Item No. **Report of the Head of Planning & Enforcement Services**

Address 14 MILL ROAD WEST DRAYTON

Development: Installation of vehicular crossover and hardstanding to front

LBH Ref Nos: **68283/APP/2011/3134**

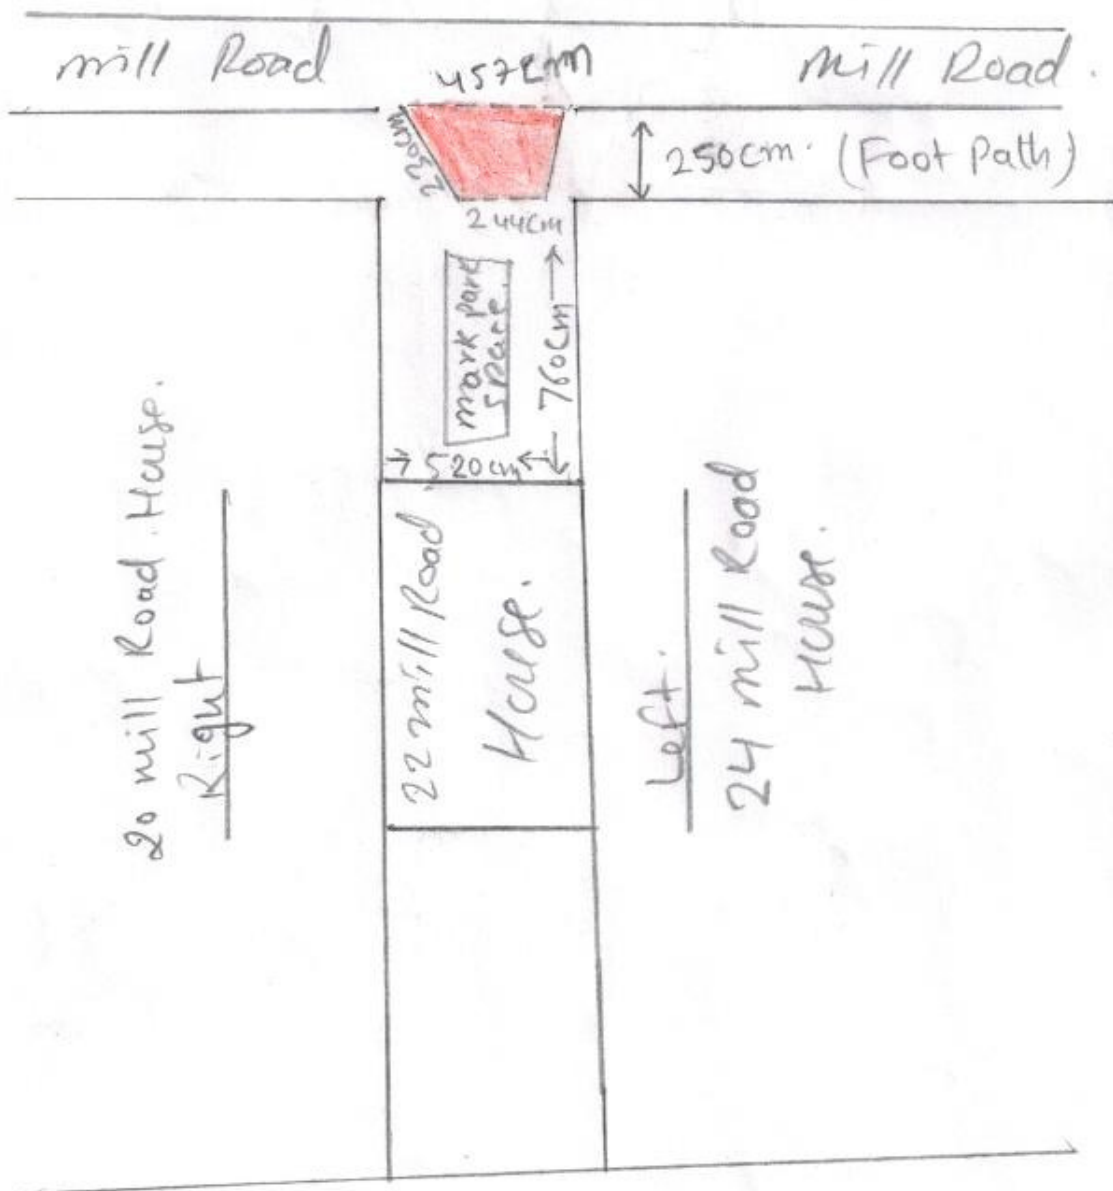
The existing proposal would be contrary to the Council's Standards and would fail to provide suitable pedestrian refuge between the proposed crossover and existing crossover servicing No.16 Mill Road.

I am of the view that our standards can be met by getting the applicant to make slight alterations by positioning the proposed access to start from the pedestrian path and reducing the access width to 2.5m at the back of the footway.

However, the proposed crossover would result in a 9.58 metre section of dropped kerb, as it would be connected to the existing crossover servicing No.16 Mill Road. Whilst a 1.5 metre separation would be provided at the rear of the footway between the two crossovers, this would not provide an acceptable area for pedestrian refuge. Therefore, the development would be considered to increase in the potential for harm to occur to pedestrians using the footway and would be contrary to Policy AM7 of the adopted UDP (Saved Policies September 2007).

The proposed crossover in combination with the existing crossover servicing 16 Mill Road would result in a combined crossover of an excessive width which would make inadequate provision for pedestrian refuge to the detriment of the safety of pedestrians and vehicles using the highway. The proposal is thus contrary to policy AM7 of the Unitary Development Plan (Saved Policies September 2007) and the adopted Supplementary Planning Document HDAS: Residential Extensions.
